From: Simon Davis
Sent: 13 May 2020 15:16
To: Peter Drury (Drew Smith) [REDACTED]
Cc: Daniel O'Shea (Drew Smith) [REDACTED]
Subject: RE: P/38/20/DOC - land to north and south of Summer Lane, Pagham

P/38/20/DOC

4 & 9 – I am awaiting a response from our Landscape Officer (I have chased)
6 – ongoing as per this email

DRAWING TITLE
GARAGE DETAILS - 1

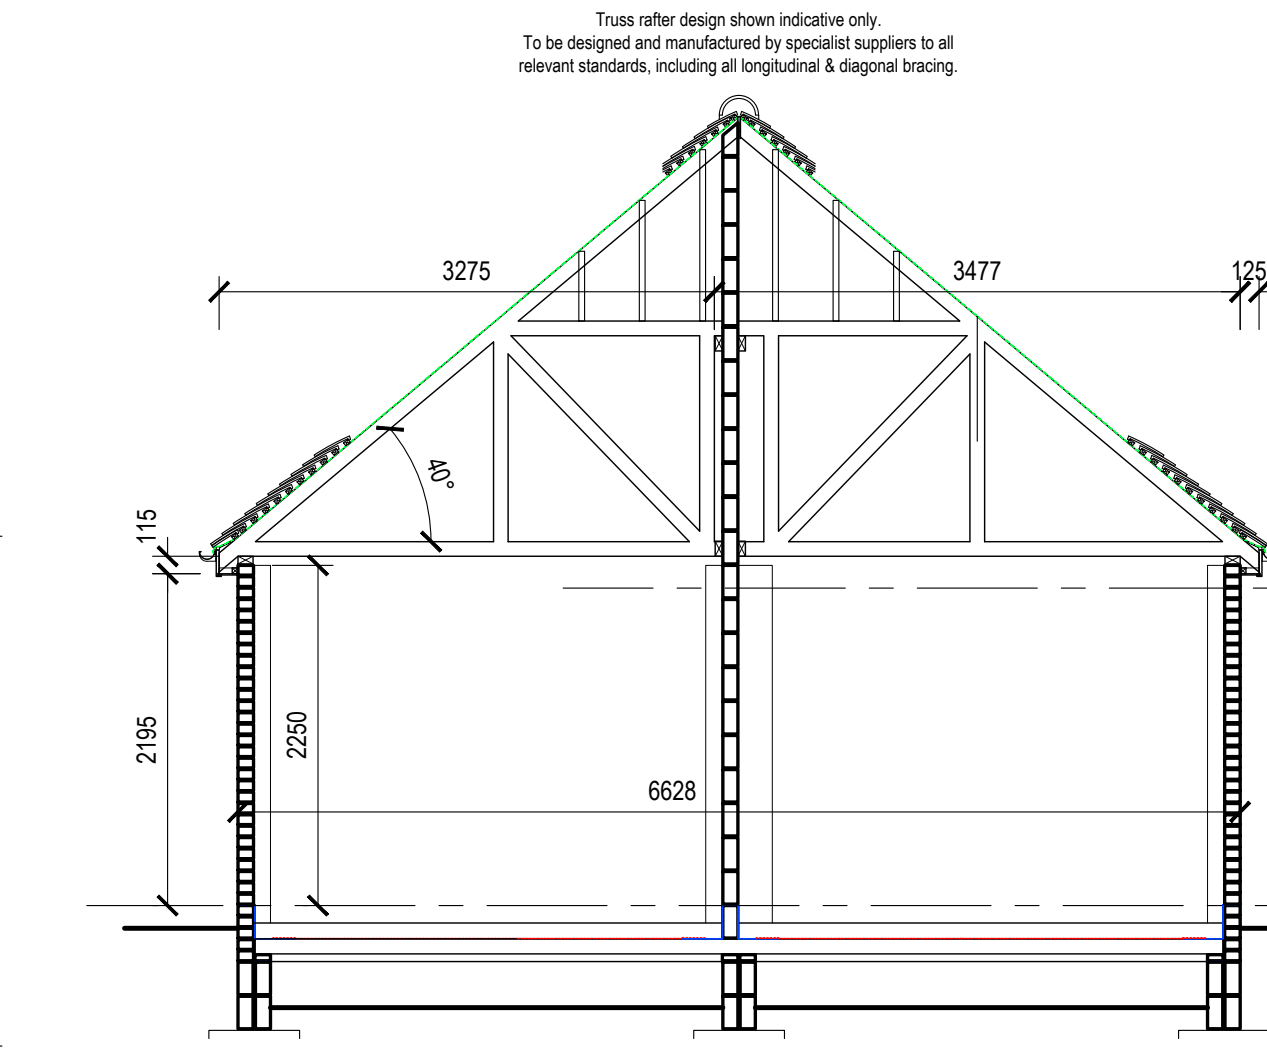
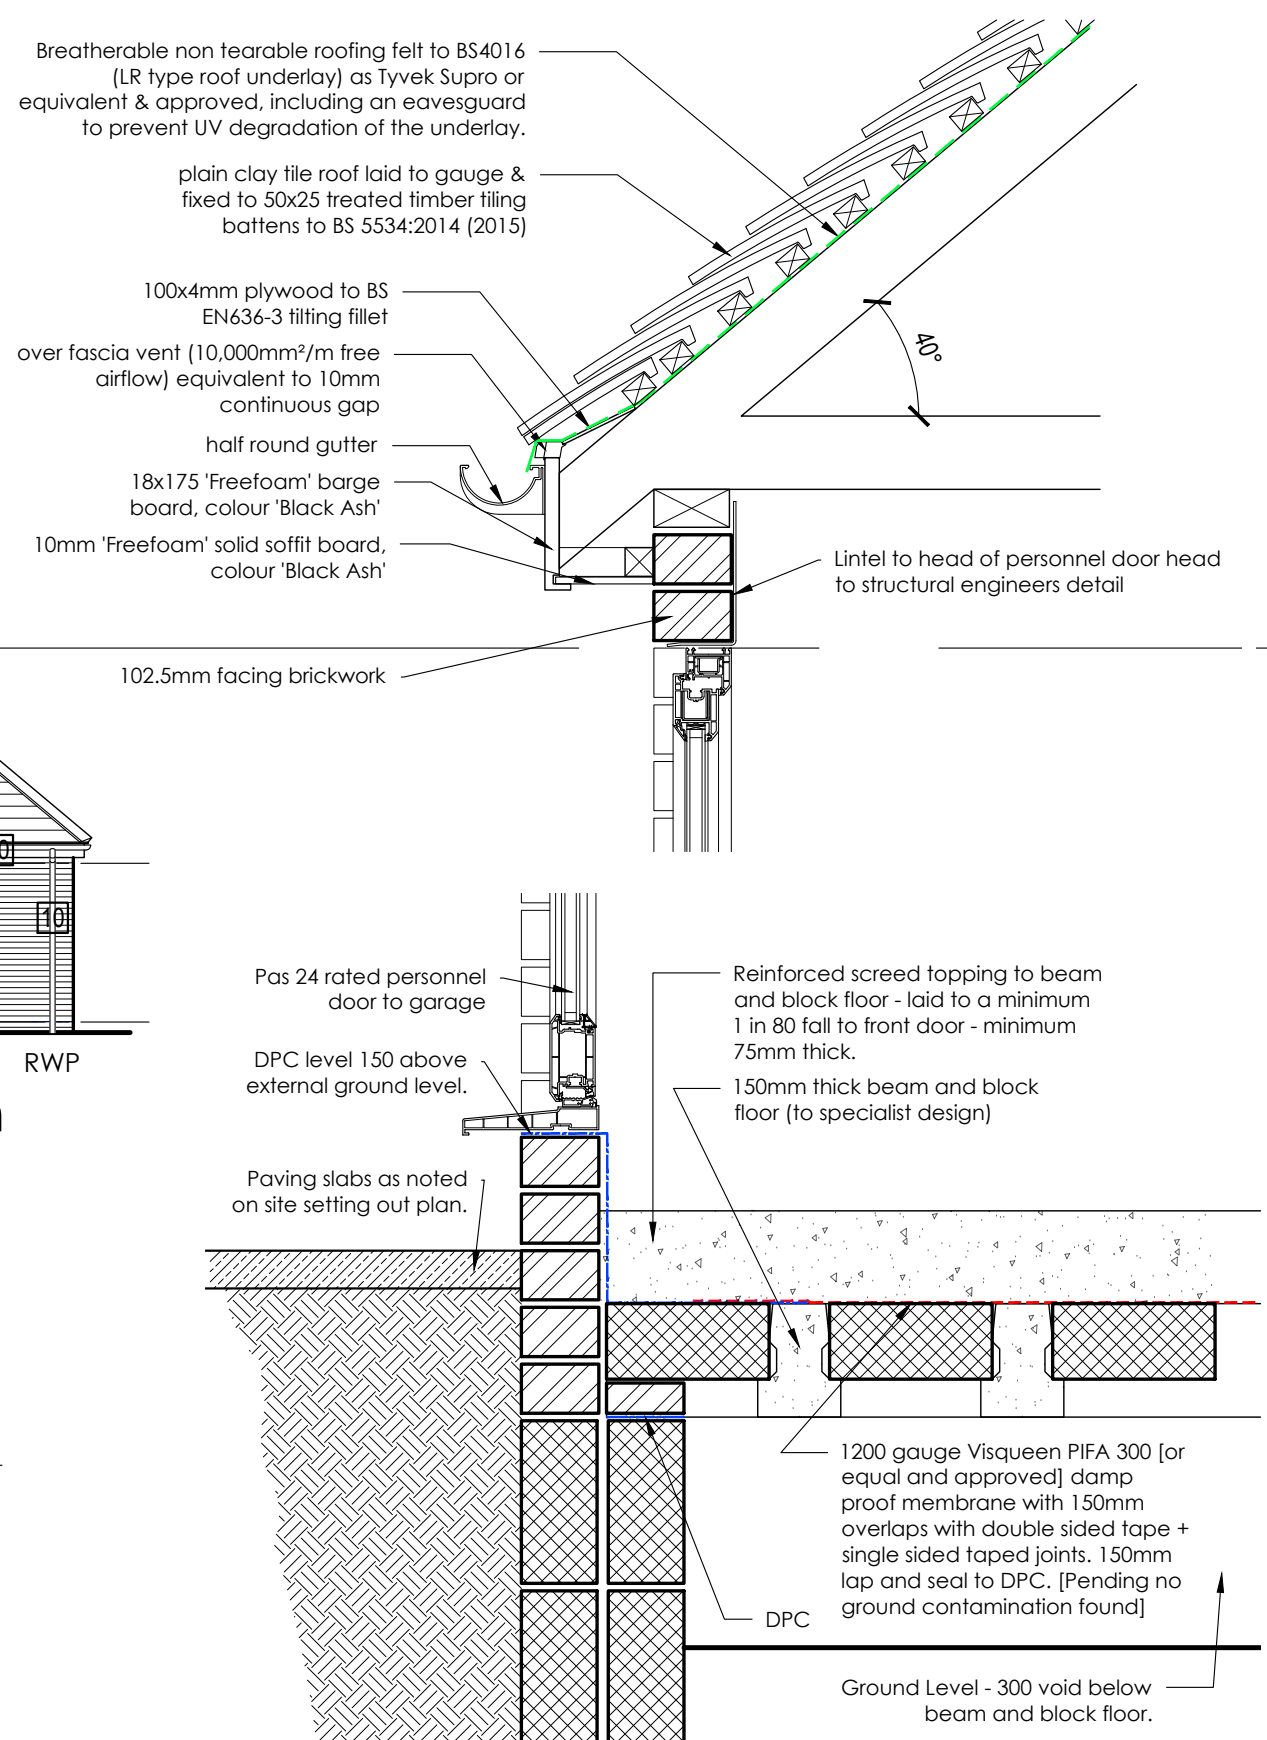
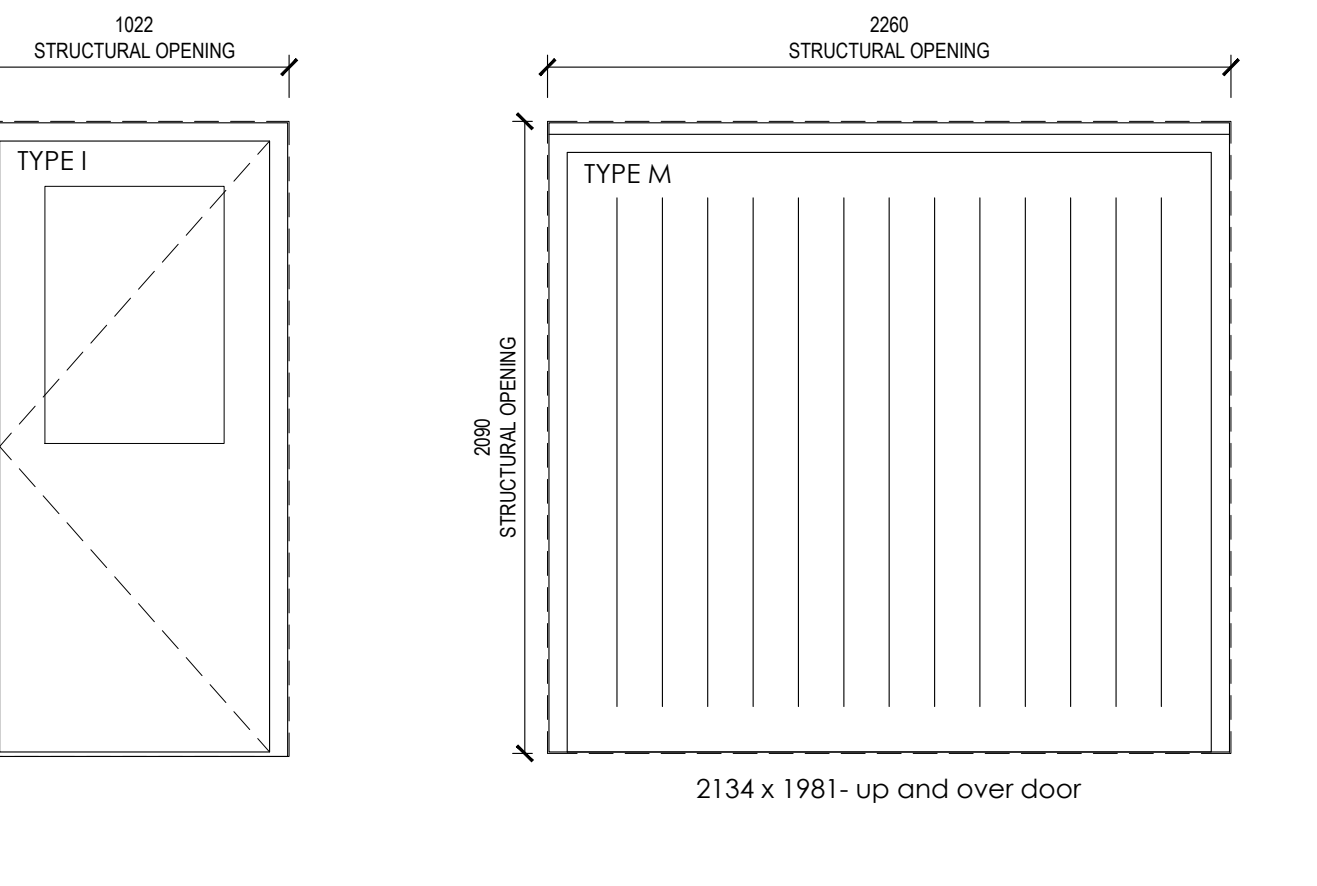
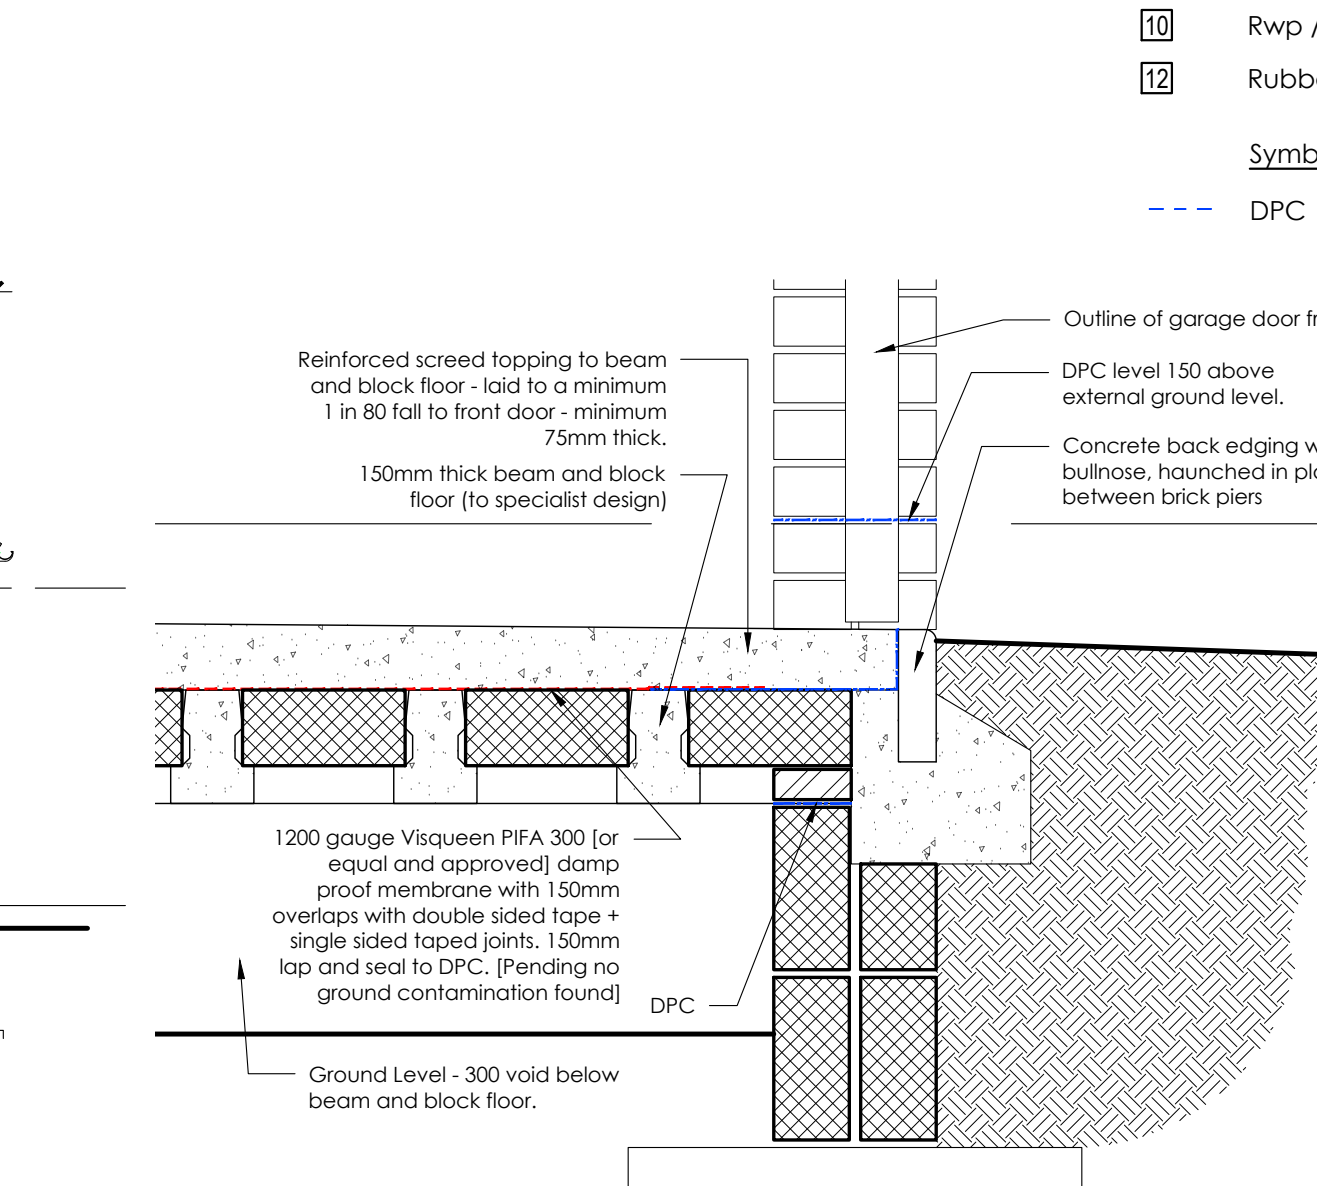
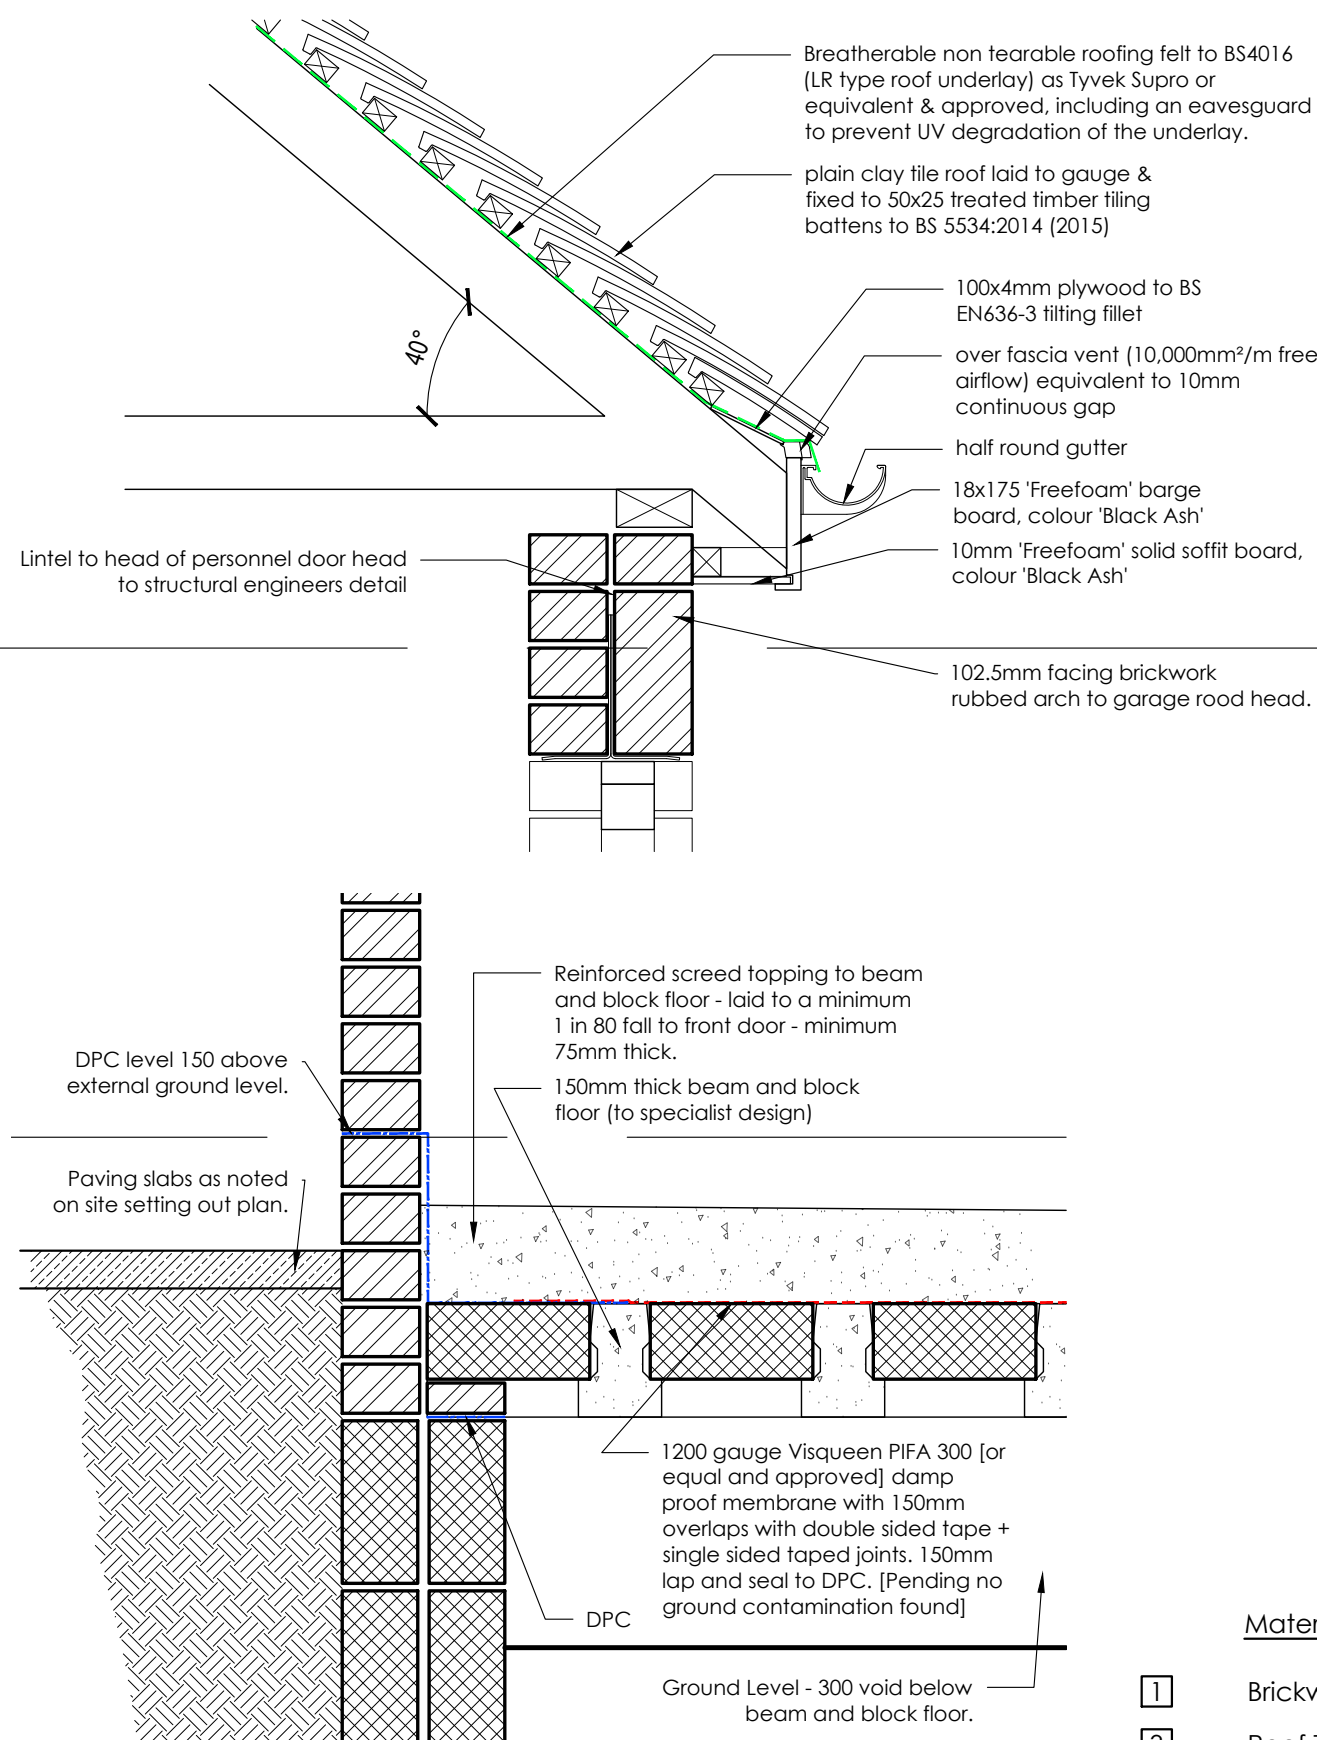
I'm sorry. I set out our position in yesterday's email based on a meeting with colleagues & my team leader yesterday however, I have since had further advice from our Group Head of Planning to say that we should be seeking an active point for all new houses with a driveway or garage. Are you willing to ensure that this level of provision is provided?

Our EHO is asking for electric vehicle charge points for all new houses with a garage or driveway. However, we don't consider that we can ask for something that is not set out in Policy (this will be changed in due course). Therefore, I will be happy to determine this if you provide active points for 100% of houses with garage and driveway and 20% of all other spaces with the remaining spaces provided with passive facilities. Can you confirm this is the case?

I agree with your statement below regarding the provision, we will proceed on this basis and I look forward to receiving your formal discharge of condition letter.
